Application H16-0711-15
Location LAKEFIELD SOUTH DROVE PODE HOLE PE11 3BD
Proposal Part change of use of existing building to a cattery, refurbish existing disused kennels with additional outdoor covered runs, also increase number of dogs from 10 to maximum of 20

Name Steve Branson
Address Environmental Health Technician Safety and Environment

Date Submitted 27-08-15
For/Against Comments

PROPOSED IMPROVEMENT TO KENNELS

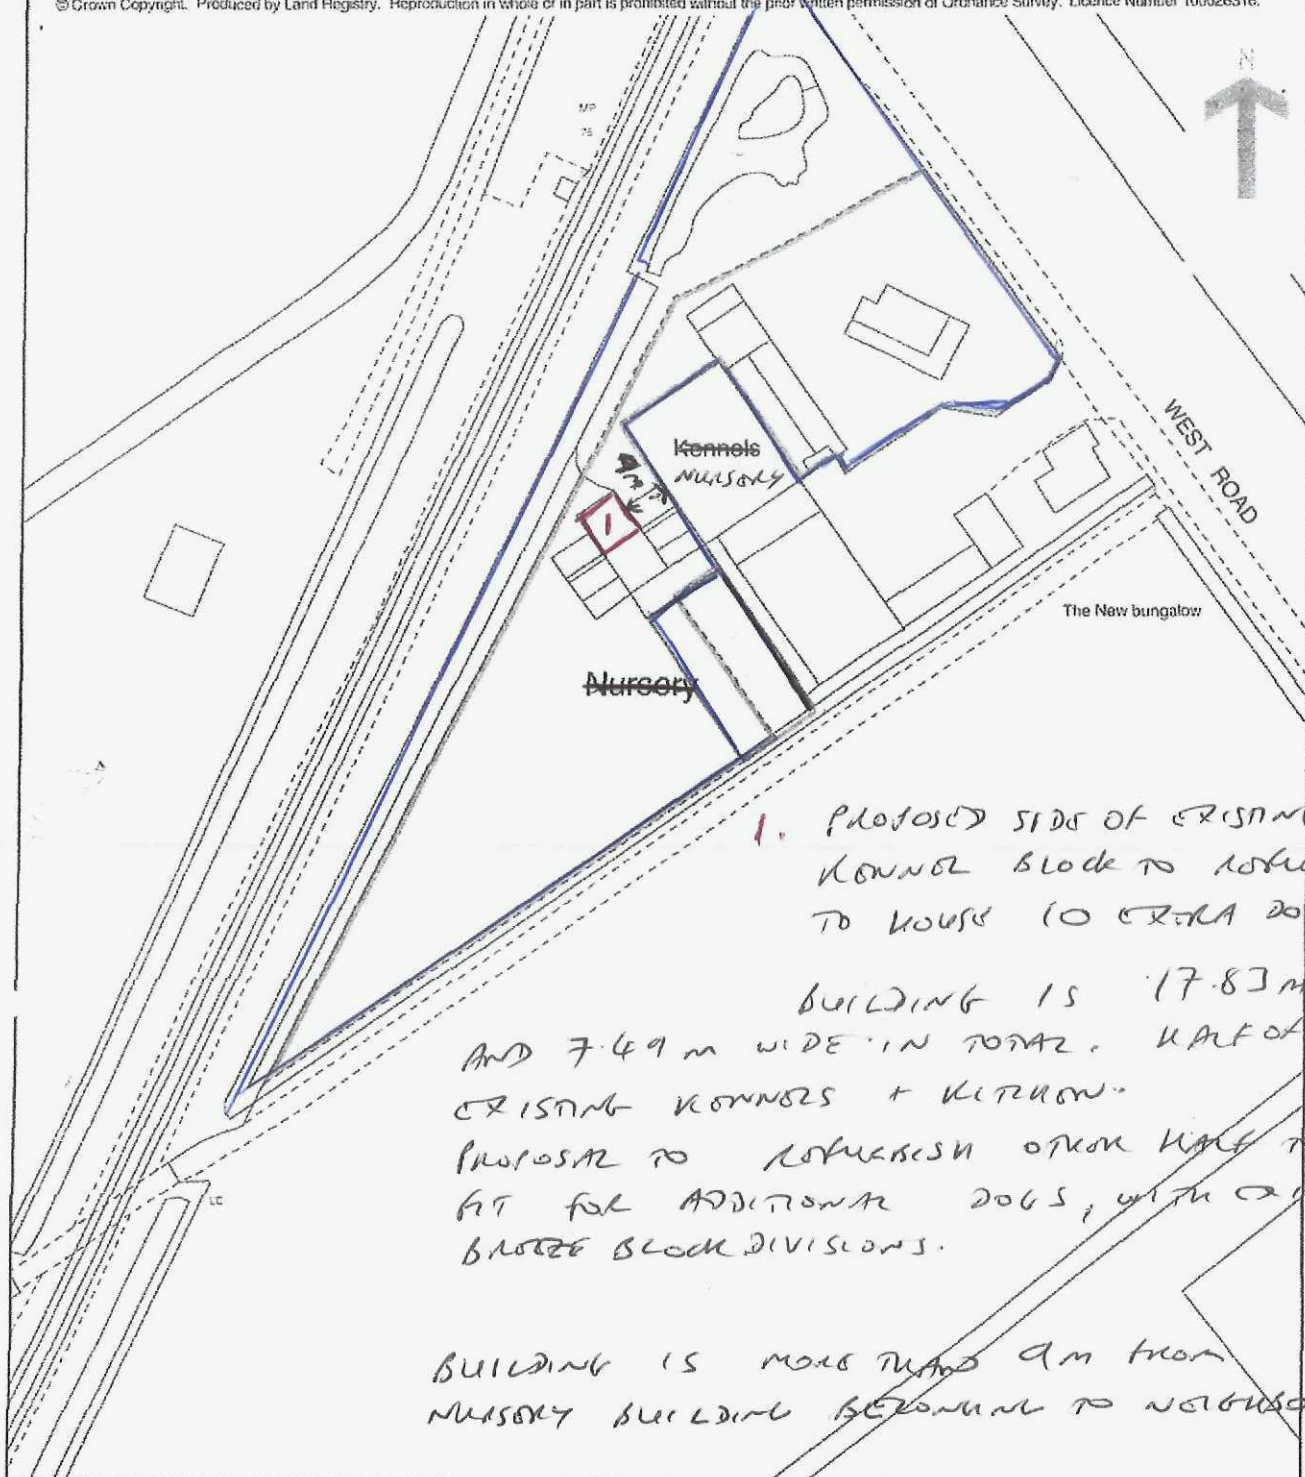
In my initial discussions with the applicant I advised her that I had no objection in principal to the increase in the number of dogs providing that the design and construction of the proposed new kennel block mirrored the existing block and, more importantly, there were no objections on noise grounds from nearby residents.

I have subsequently been contacted by the nearest neighbour who informed me that they regularly experience noise from dog barking. They have confirmed this in their letter of objection. I understand that there has been a further objection from another neighbour on noise grounds.

Following further discussions with my colleagues in the Environmental Protection team I am concerned that any increase in the number of dogs will increase the potential for complaints and therefore I object to this part of the application.

PROPOSED CHANGE OF USE TO CATTERY

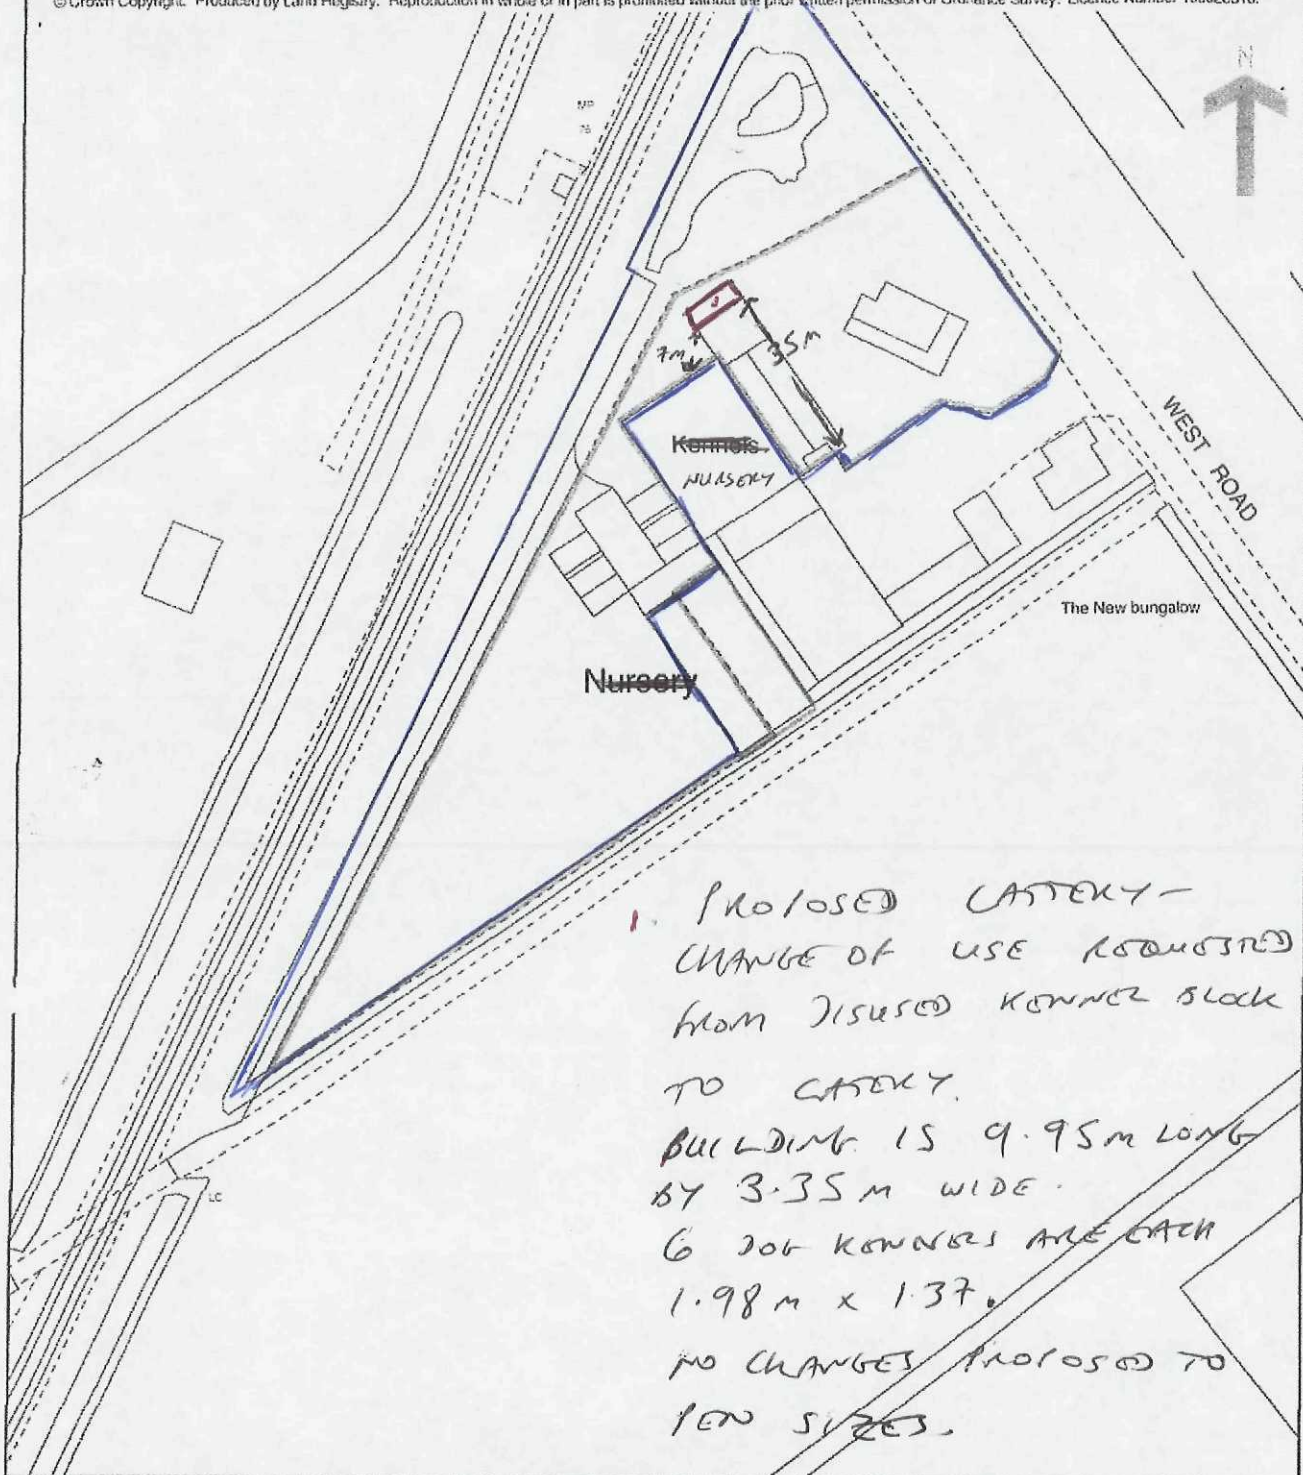
I have no objection to the use of part of the site as a cattery providing there are adequate arrangements for the storage and disposal of waste.
